**From:** Cornelis Duba <Cornelis.Duba@endeavourenergy.com.au>  
**Sent:** Friday, 28 September 2018 12:32 PM  
**To:** DPE CSE Information Planning Mailbox  
**Cc:** Teresa Gizzi  
**Subject:** NSW Planning & Environment Notice of Exhibition State Significant Development SSD 8980 RE Bowral and District Hospital Redevelopment  
**Attachments:** Endeavour Energy MCI+0006+S07 Substations & Switching Stations.pdf

I refer to the Department's letter of 27 August 2018 regarding State Significant Development SSD 8980 at 97-103 Bowral Street, Bowral (Lot 4 DP 858938) for 'Bowral and District Hospital Redevelopment'. Submissions needed to be made to the Department by 27 September 2018. I apologise for the late submission but trust that Endeavour Energy's recommendations and comments will still be considered.

Figure 49: Service vehicle access routes (Source: MSJ & GTA)

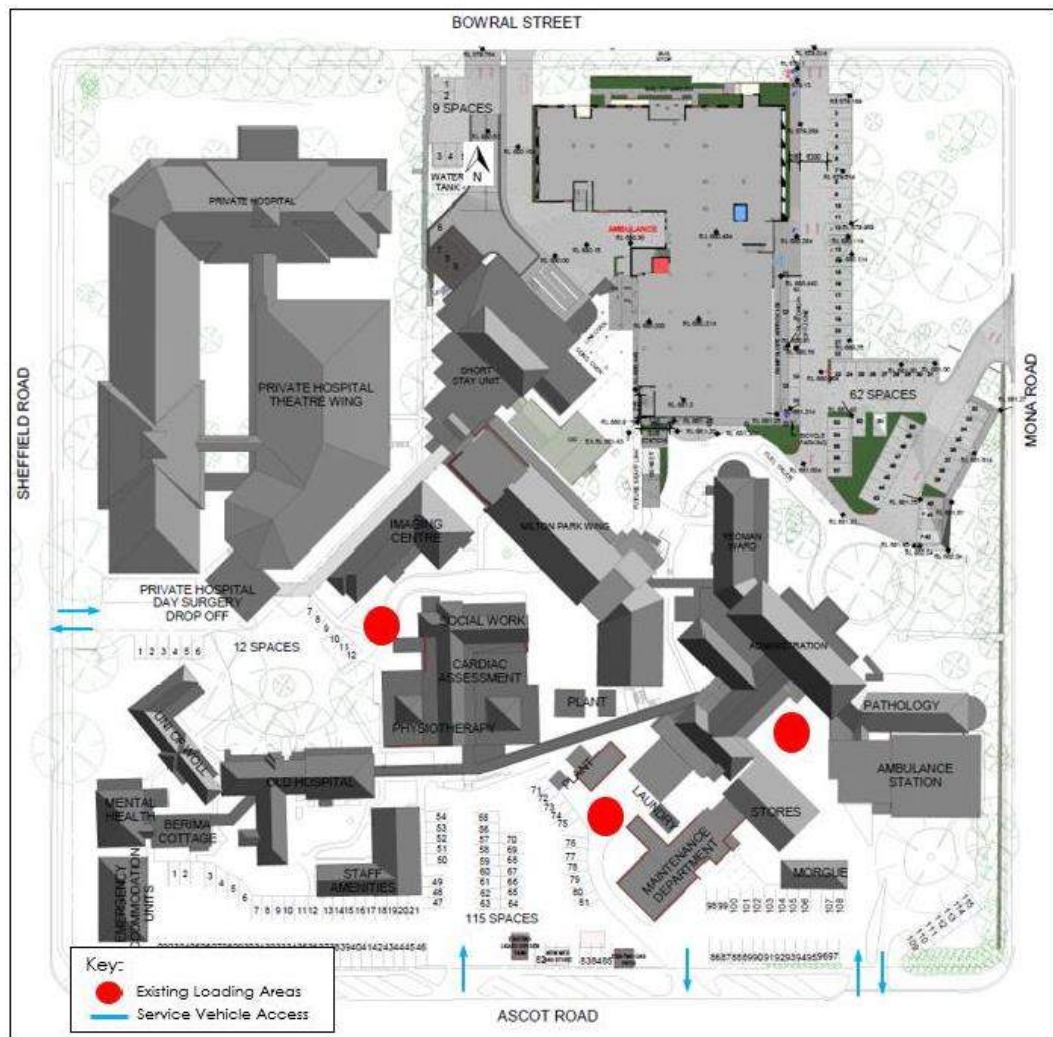
The fact that provision is being made for the substation is a positive. Endeavour Energy's general requirements is for a padmount substation easement to have a minimum size of 2.75 x 5.5 m and also have the additional restrictions for fire rating (and possibly swimming pools and spas which in this instance does not appear to be applicable) which should not affect any adjoining property, be at ground level and have direct access from a public street or be supported by an appropriate right of access. Generally it is the Level 3 Accredited Service Provider's (ASP) responsibility (engaged by the developer) to make sure that the substation location and design complies with Endeavour Energy's standards the suitability of access, safety clearances, fire ratings, flooding etc.
